From: [Eric Solly](#)
To: [Kelly Bacon \(CD\)](#)
Subject: Re: SX-20-00001
Date: Thursday, February 27, 2020 11:56:35 AM
Attachments: [Streissguthsiteplans.pdf](#)

PARTIAL SITE PLAN
 SCALE 1"=50'-0"

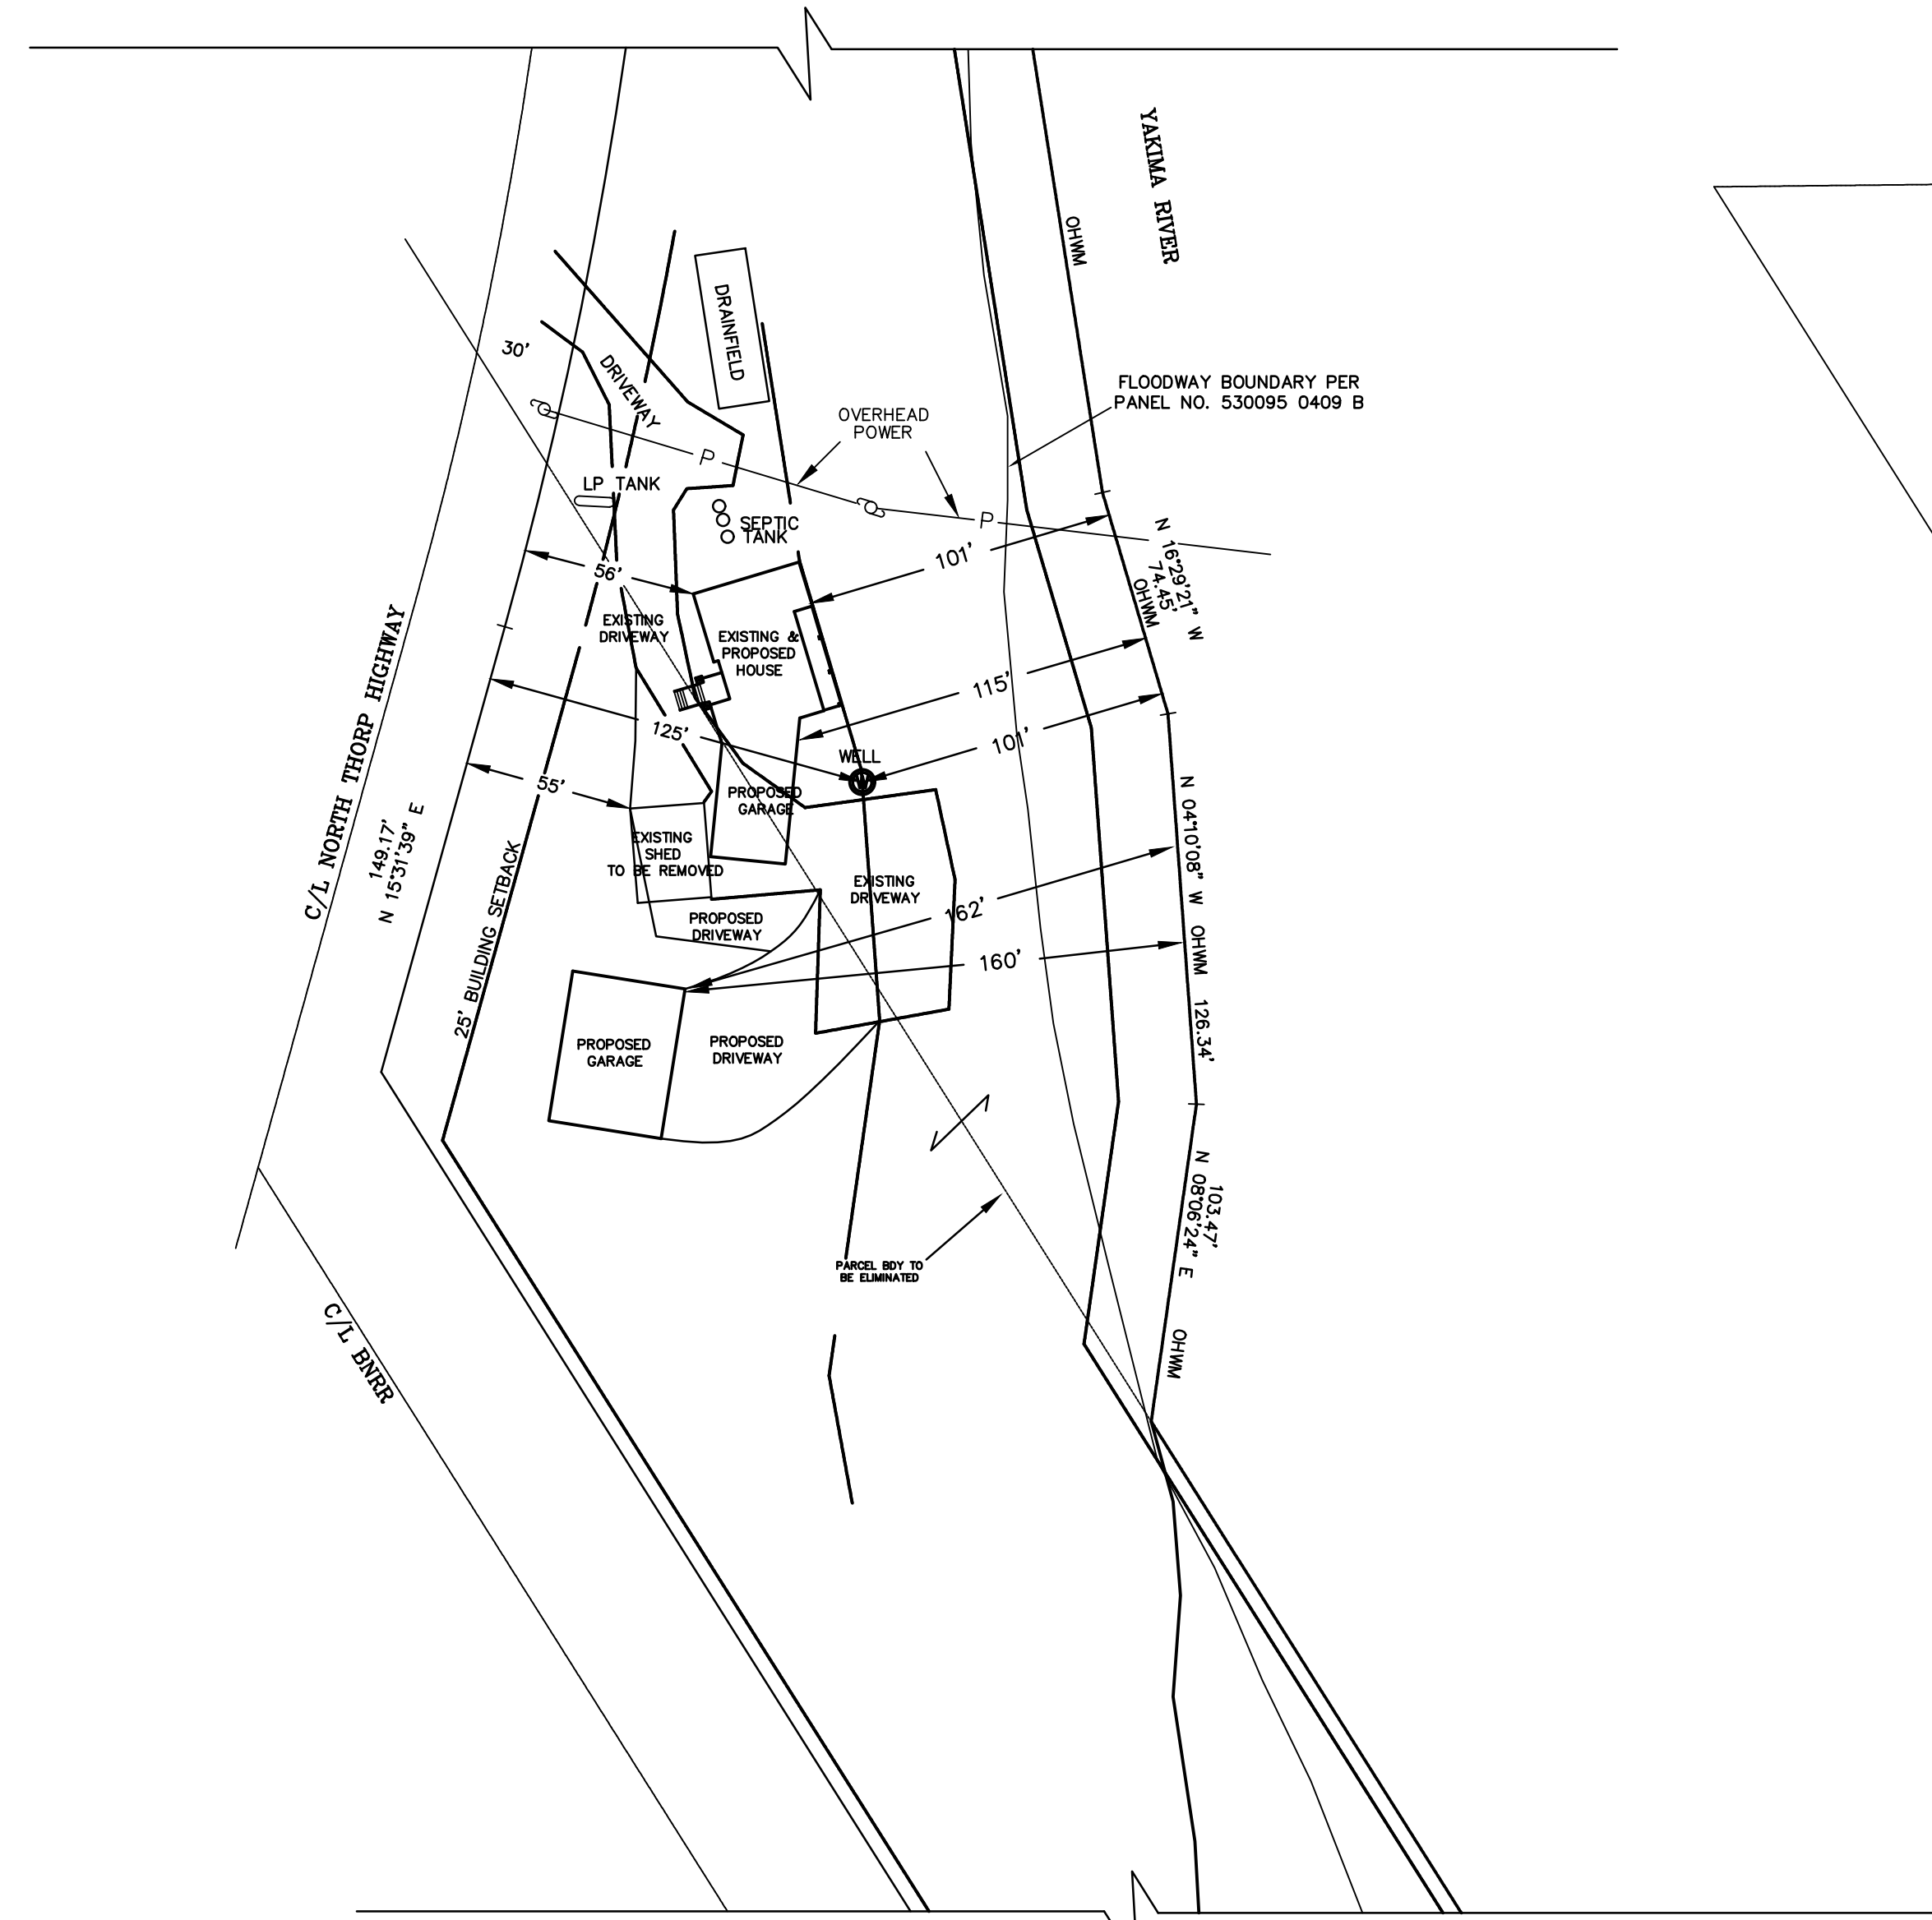
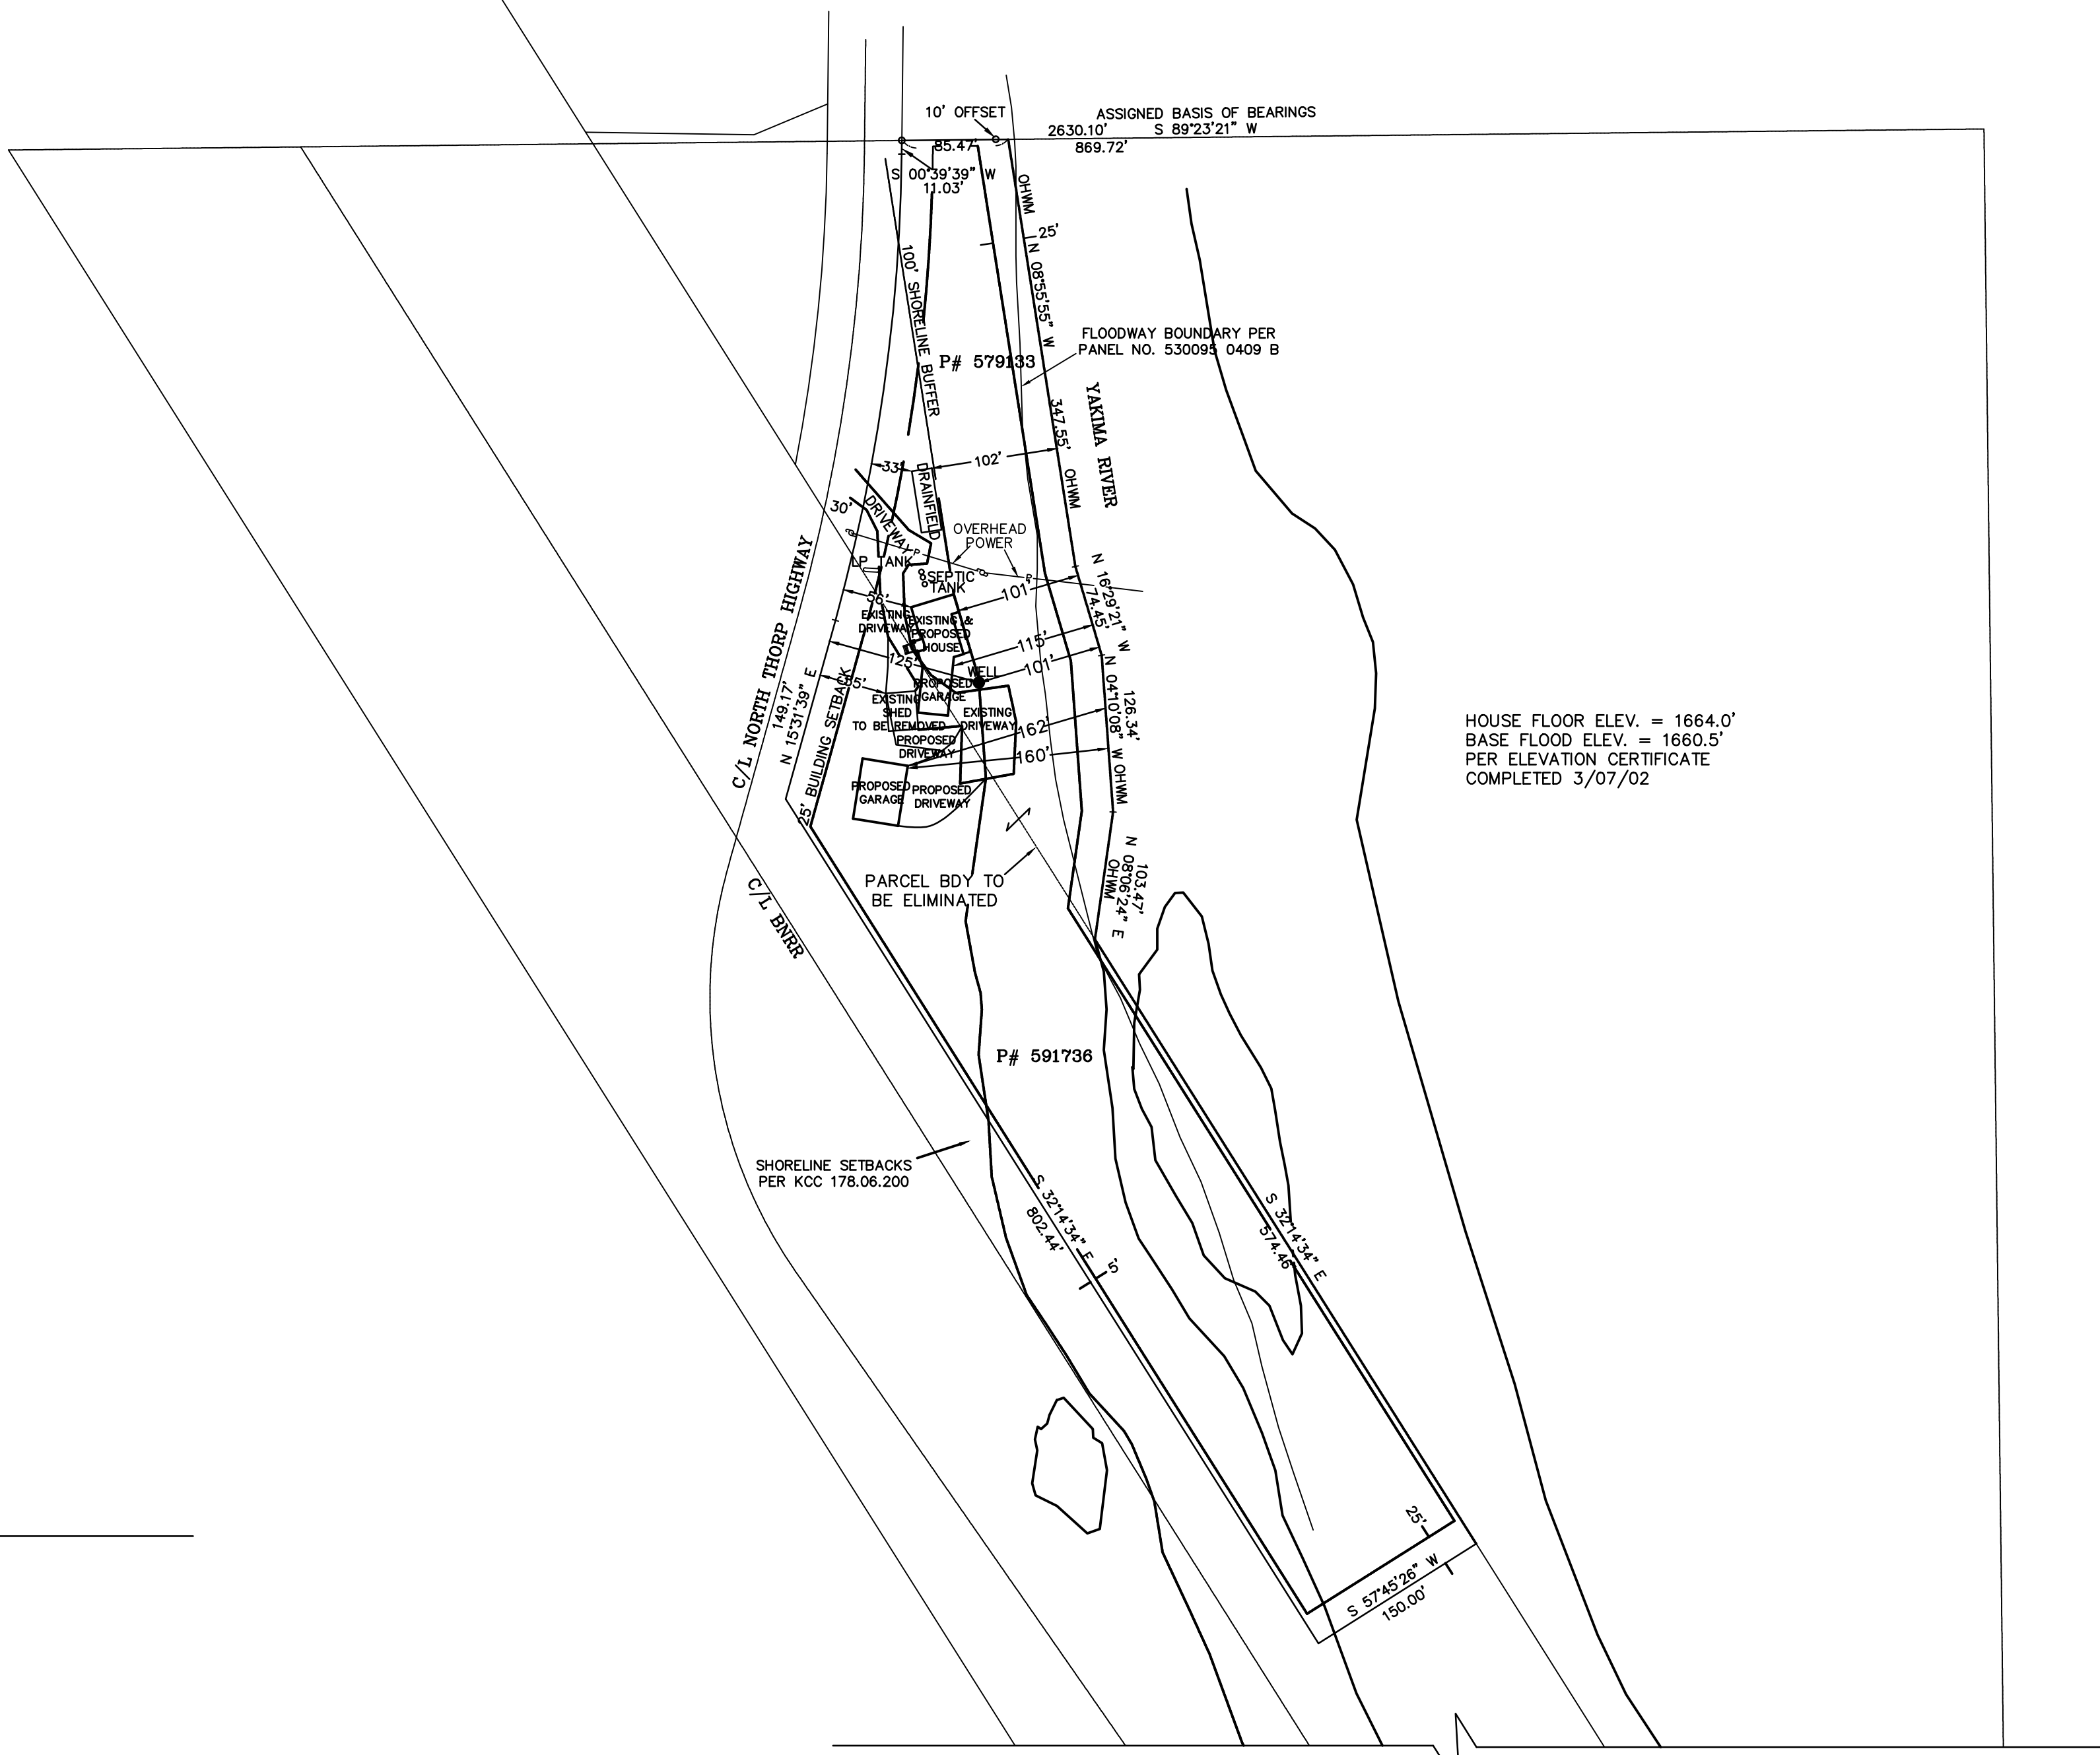
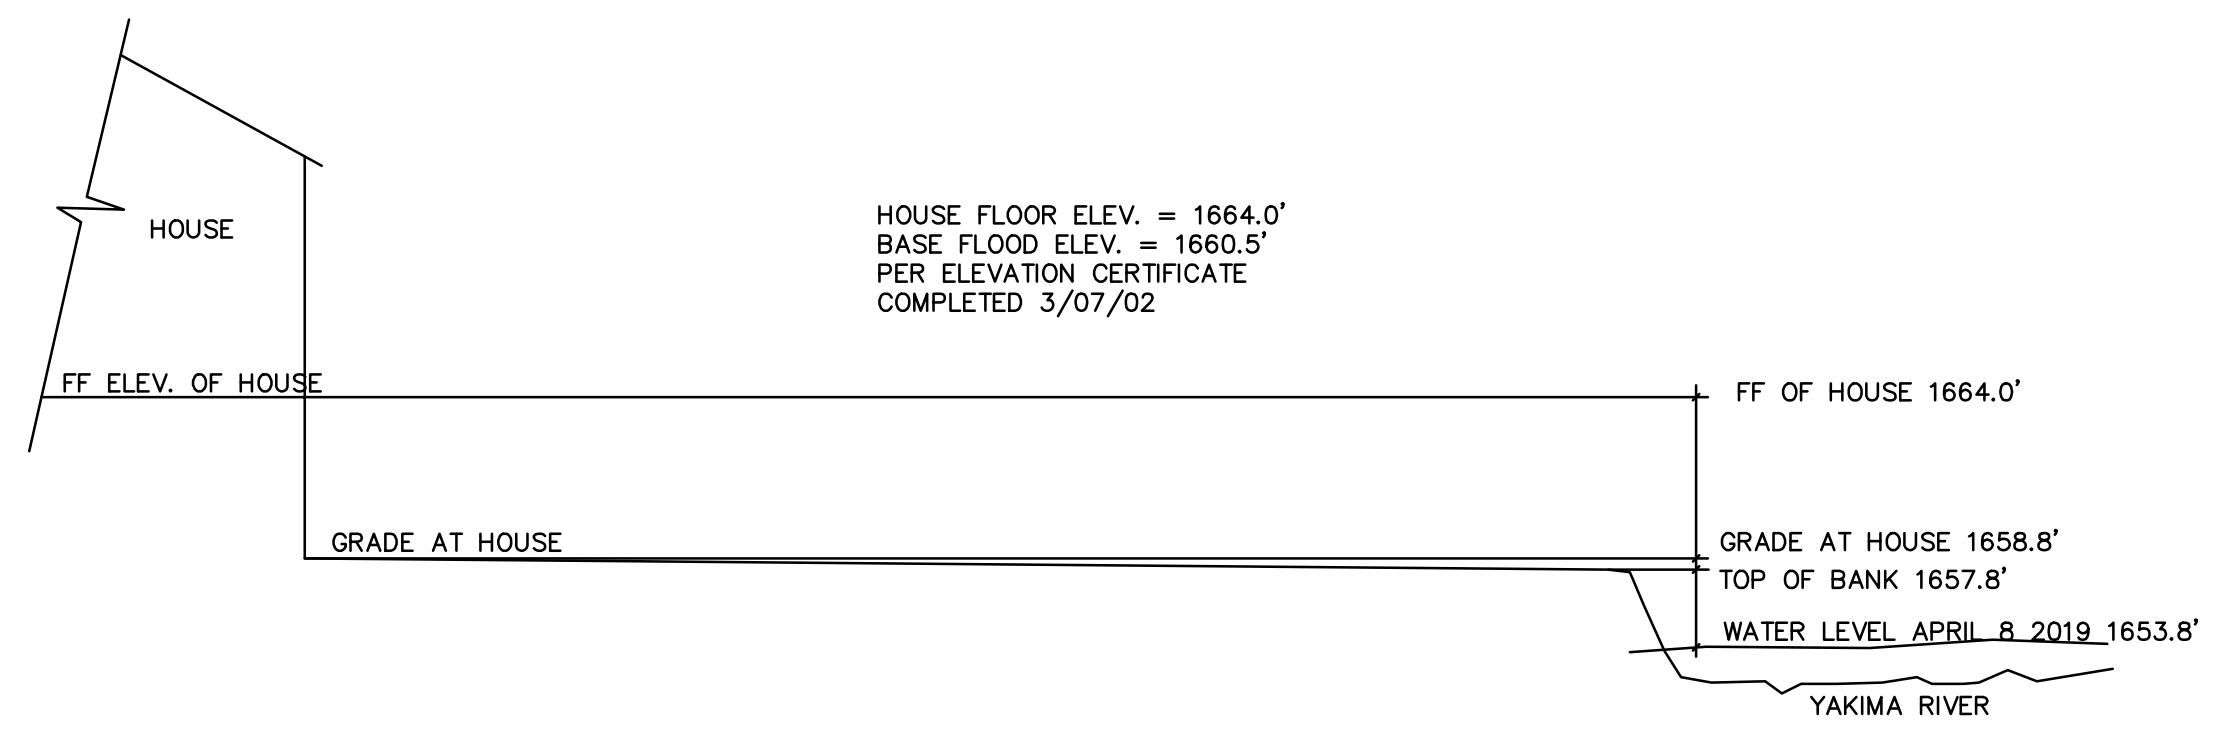
In my review I noticed the scale is off on both drawings. Please submit updated site plans with corrected scale.

I'm so sorry Kelly. Here are the new one's labeled correctly. Thanks Eric
